Development Control  
Ribble Valley Borough Council

**App no: 24.0484**

**Address: Ramsgreave Bakery Pleckgate Road Ramsgreave**

**Proposal: Proposed demolition of existing warehouse structure and erection of two separate blocks of industrial units (use class B2/B8) comprising one block of five units, each with a mezzanine floor and one block of two units each with a mezzanine floor, including associated car parking and service yard.**

Site Plan - as proposed, scale 1=200

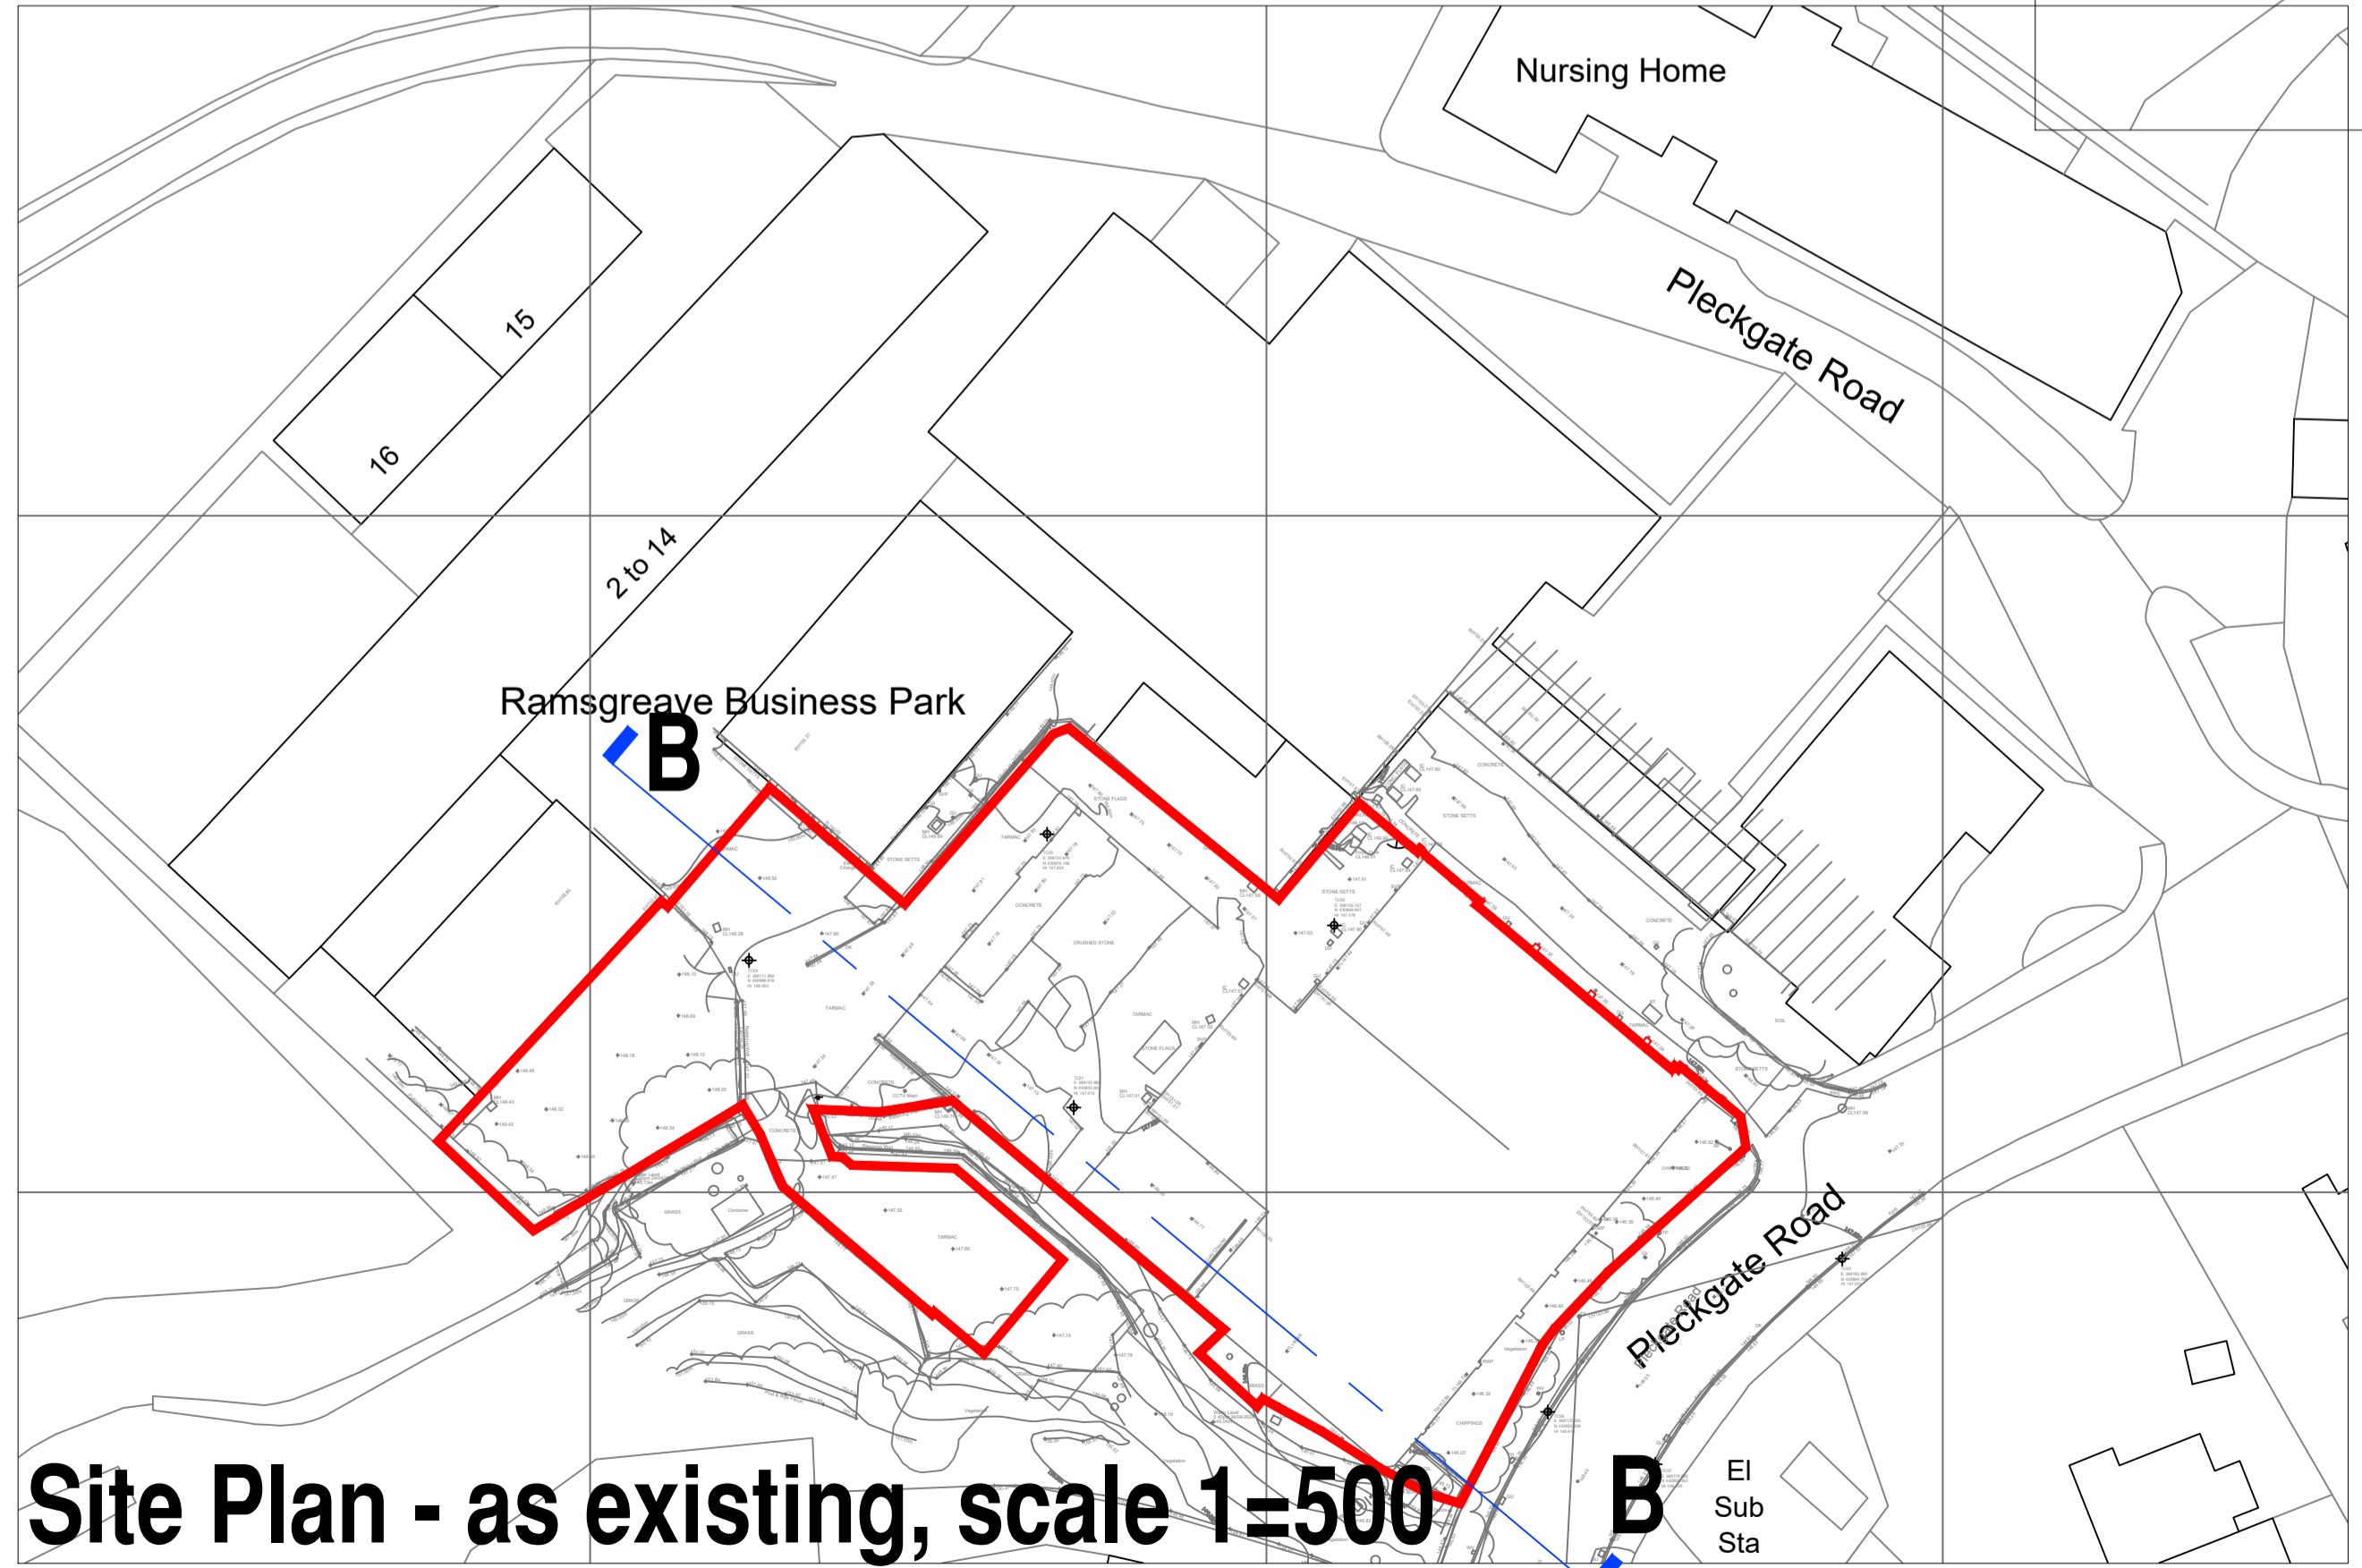
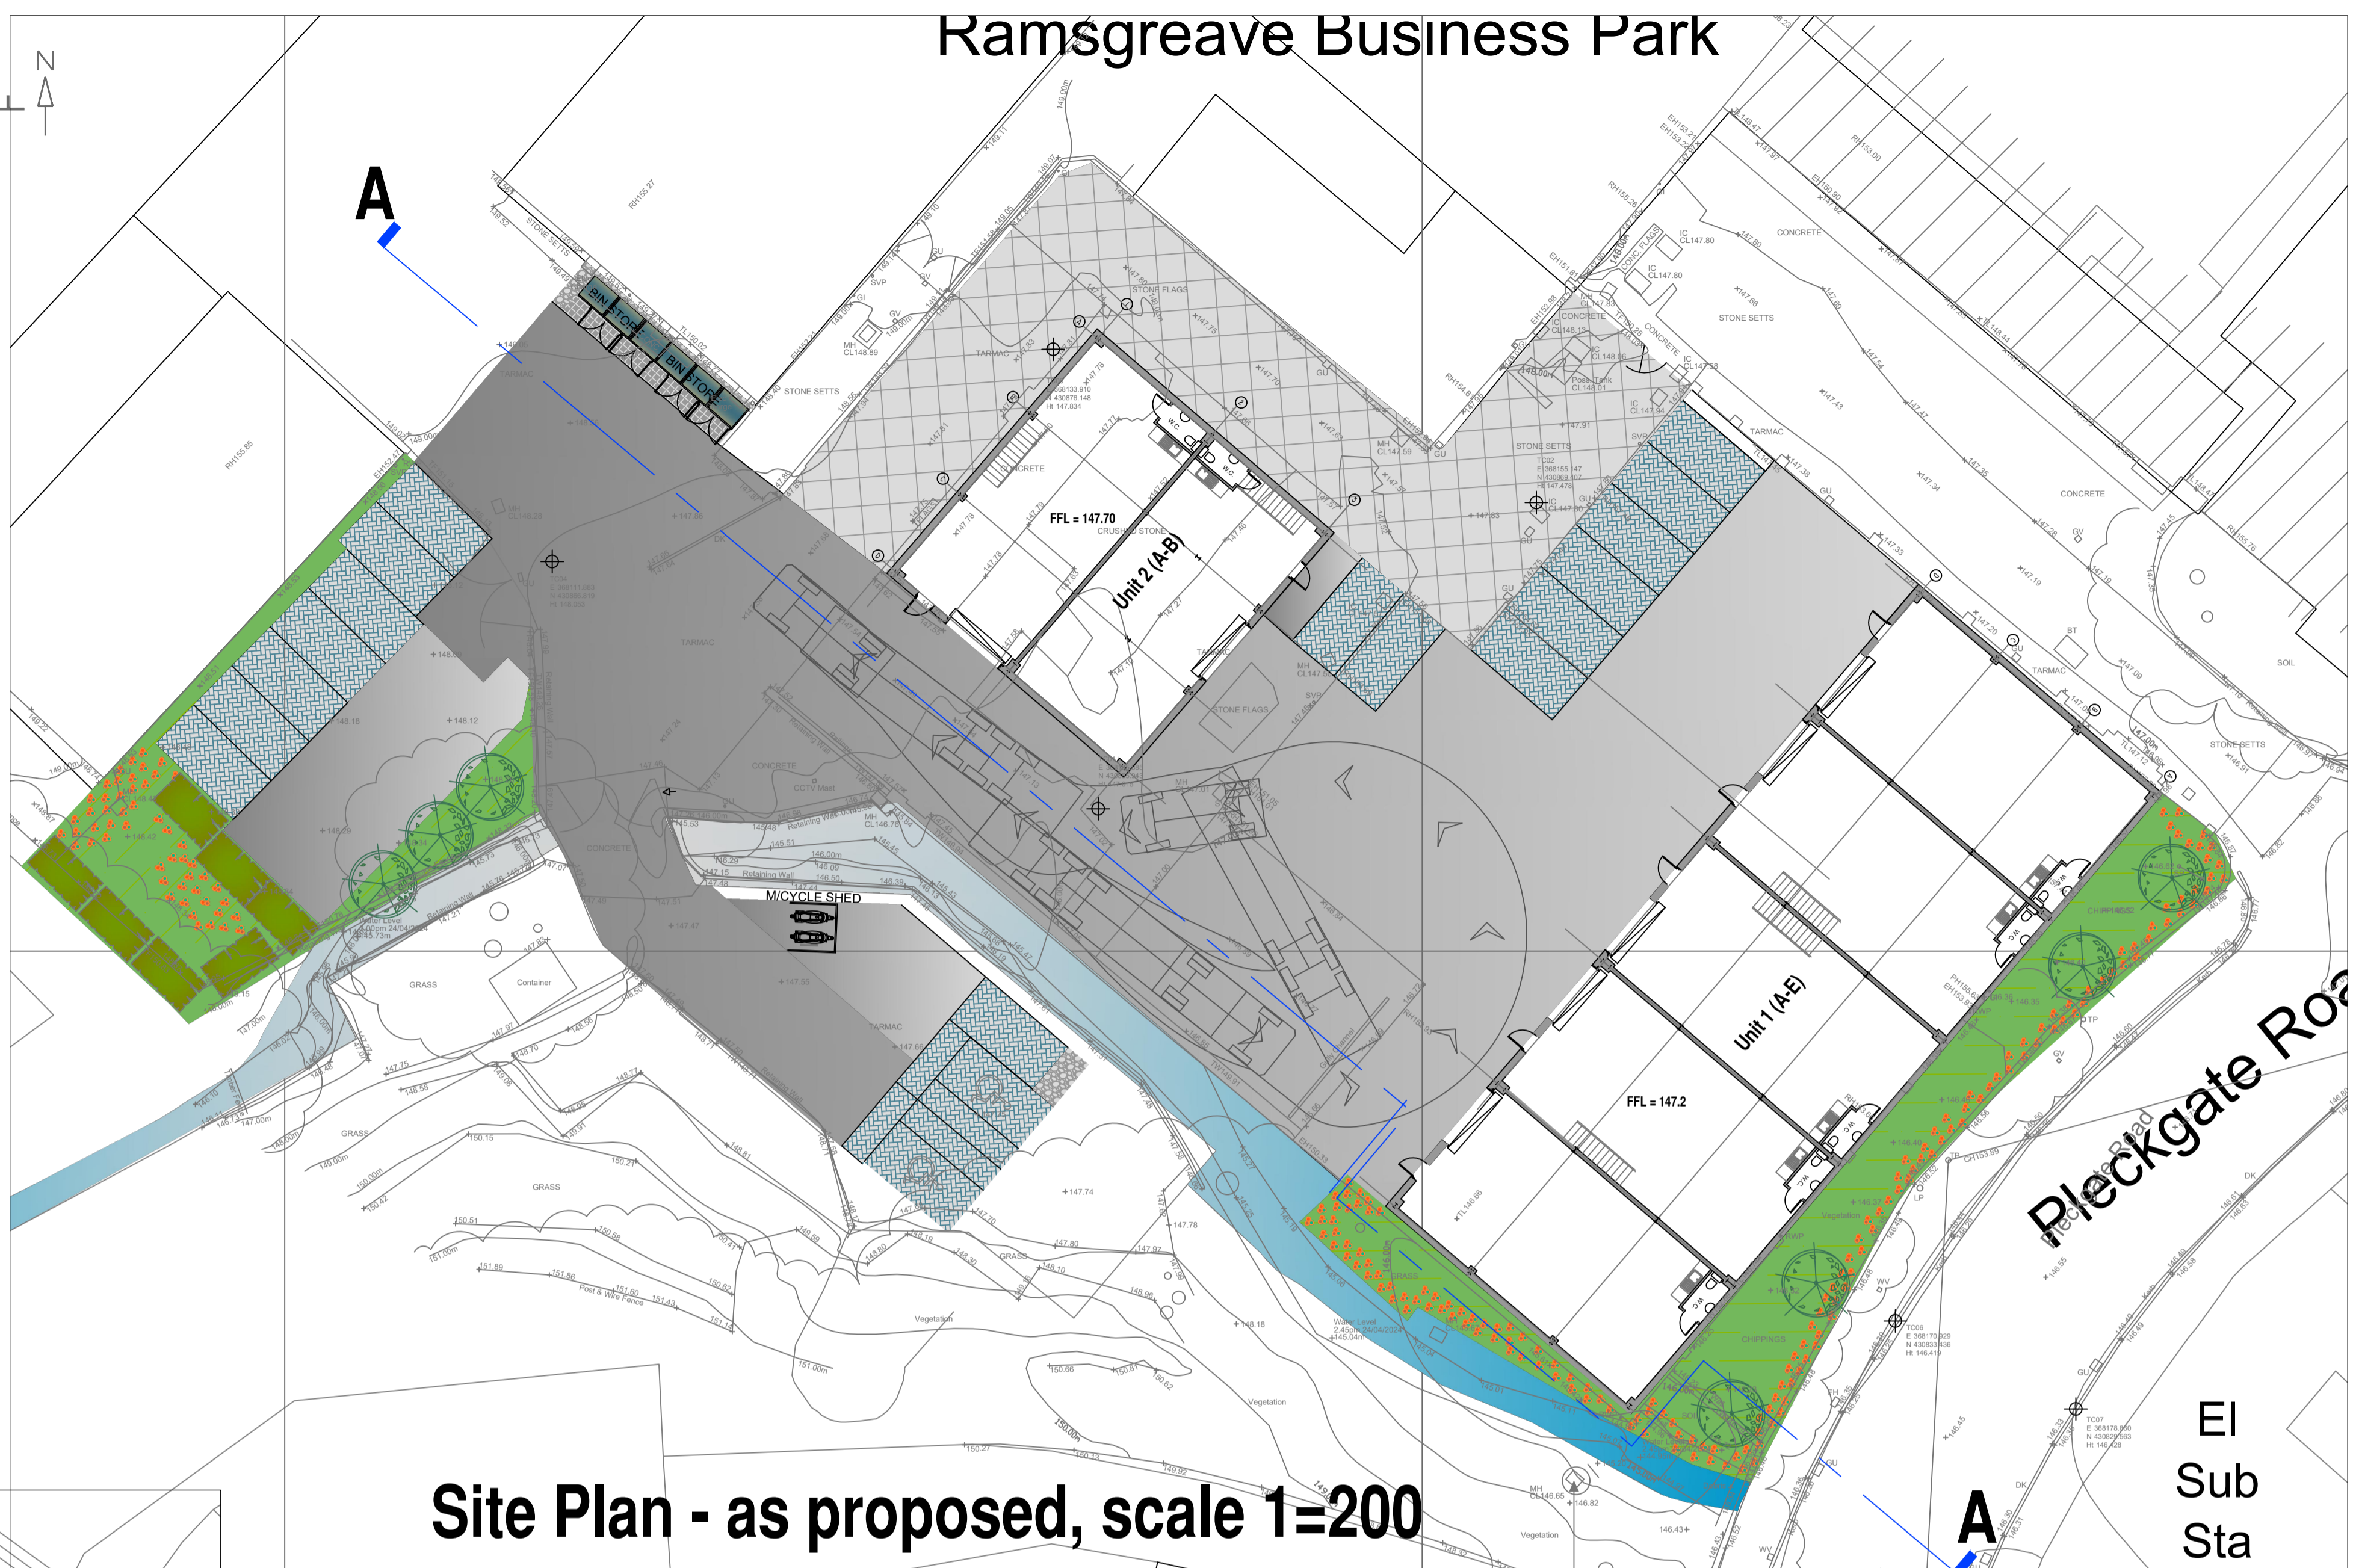
Access to the site is via a privately maintained access road and shown on drawing 'Site access route – 187-07 Rev B'. There is a swept path for an articulated wagon shown exiting the site access onto Pleckgate Road and turning within the yard. When visiting site it is apparent that due to the existing car parking which occurs at the neighbouring units that an articulated vehicle could not be able to access the site. A smaller vehicle would need to be used and a swept path should be submitted

for the full route, including showing the vehicle entering, turning and exiting onto the private access road in forward gear with the existing car parking included.

As detailed above the use of articulated wagons at the site is not considered appropriate due to the existing access constraints and parking at neighbouring premises.

The proposed units do not appear likely to require this size of vehicle to their relatively small size. We would request that a smaller 12m rigid goods vehicle is tracked as described above.

**Location Plan** 0 20 40 60 metres

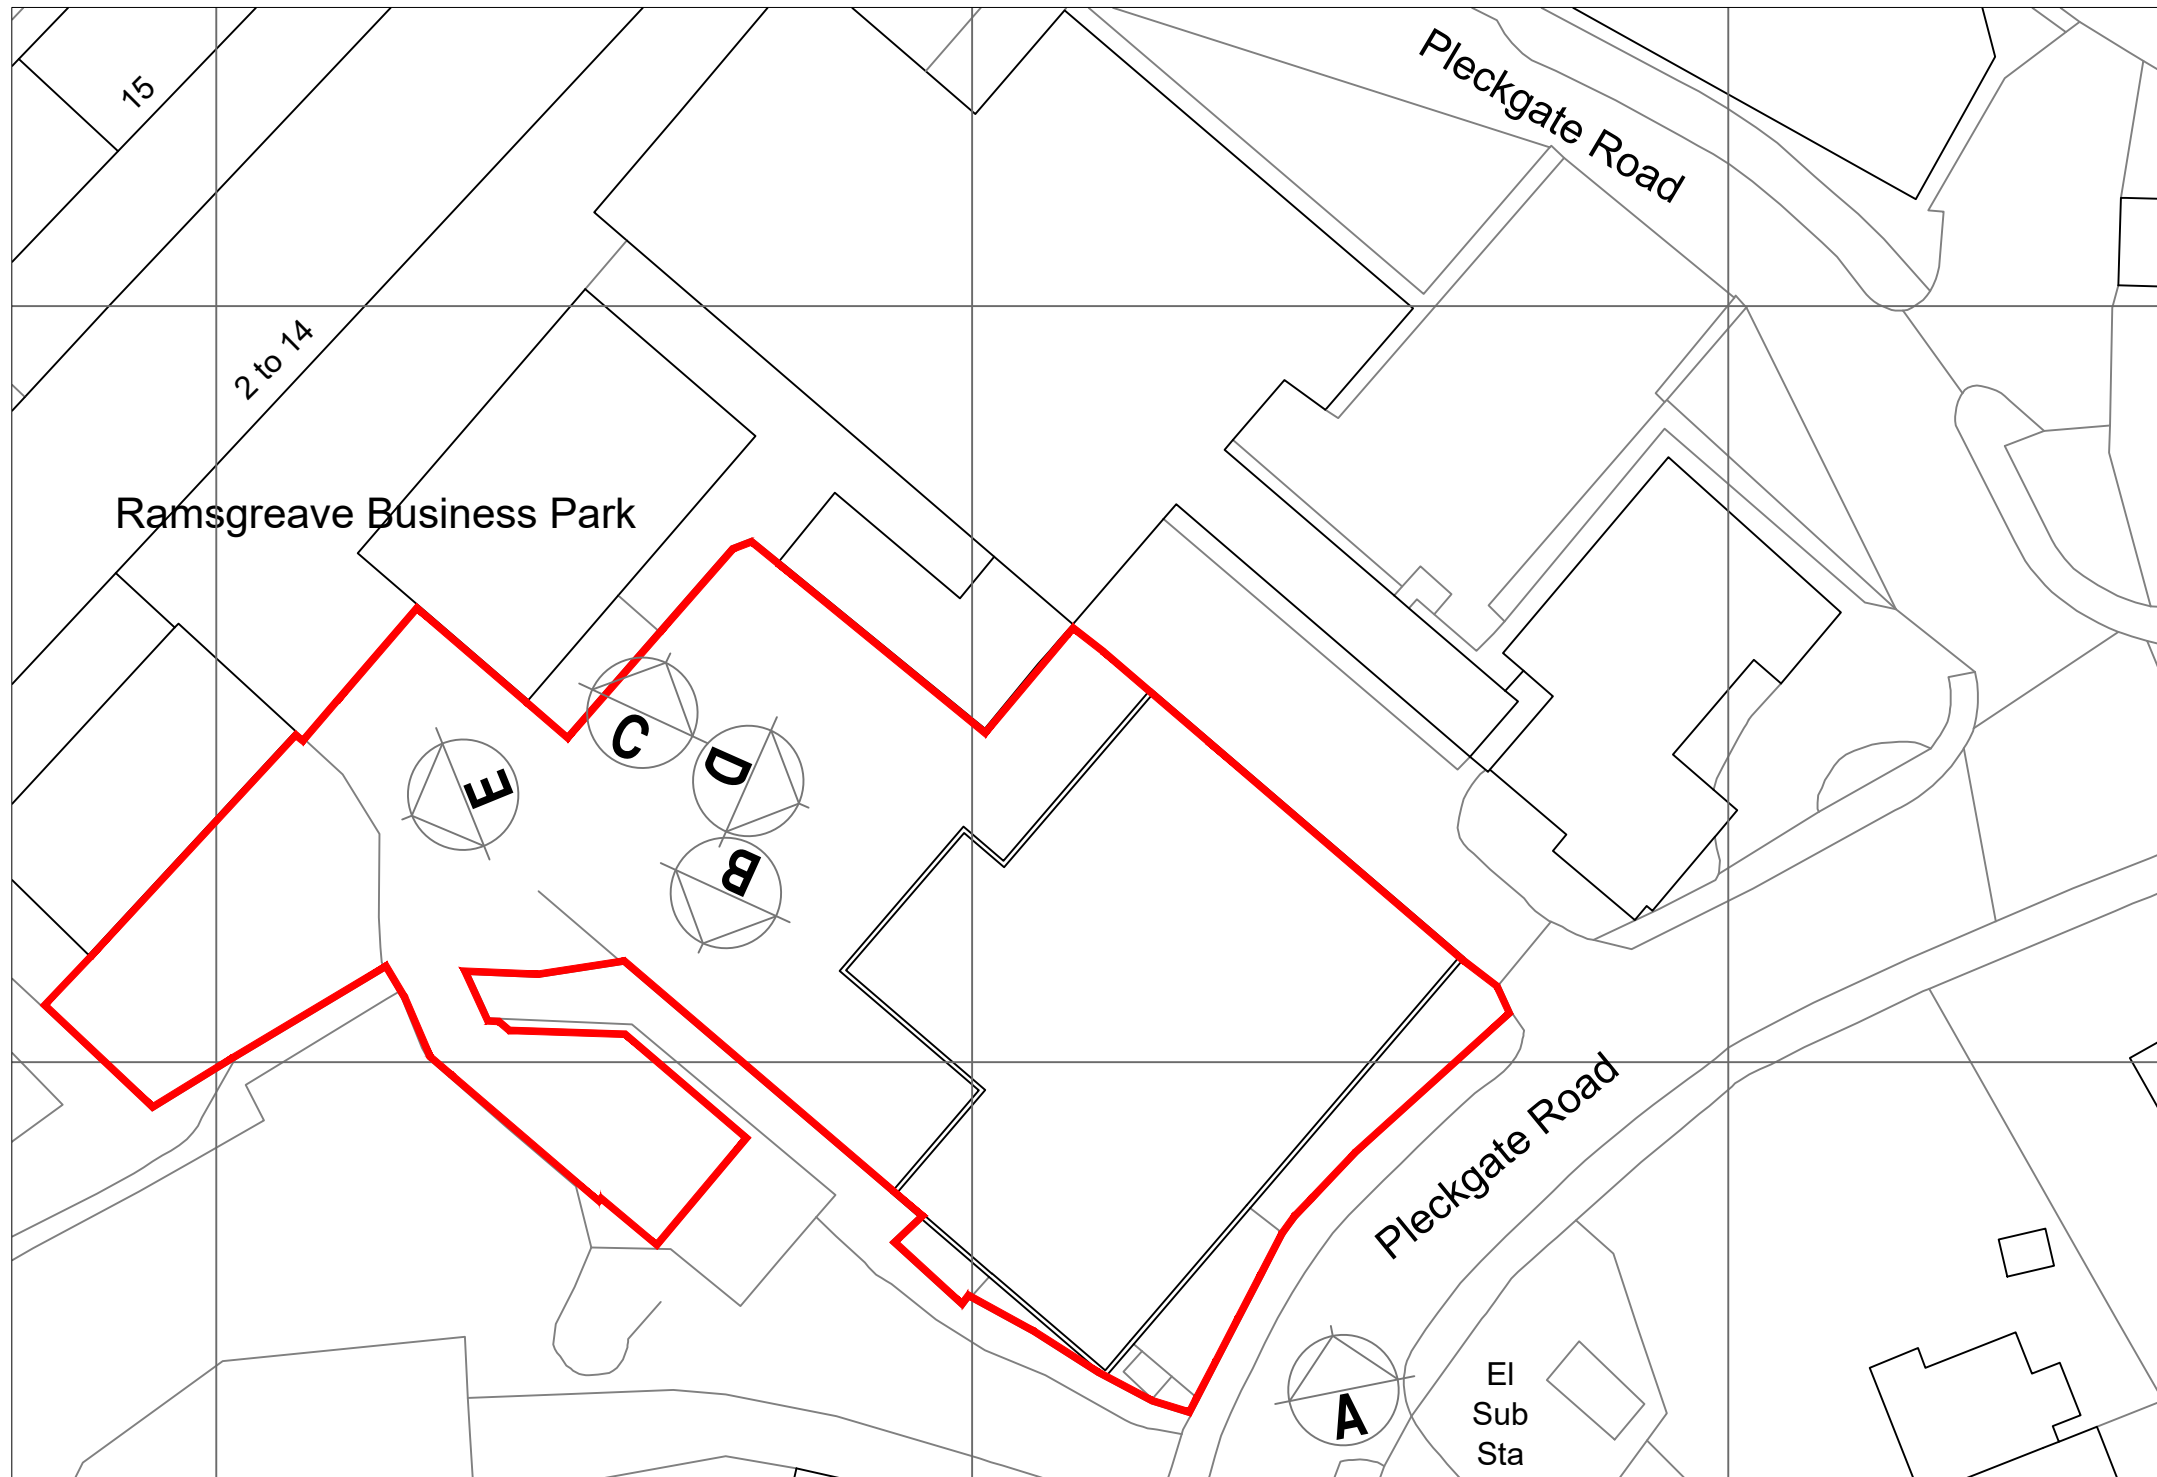
The full site access route up to Pleckgate Road should be included in the red edge and the applicant should demonstrate that they have a right of vehicle access over the land.
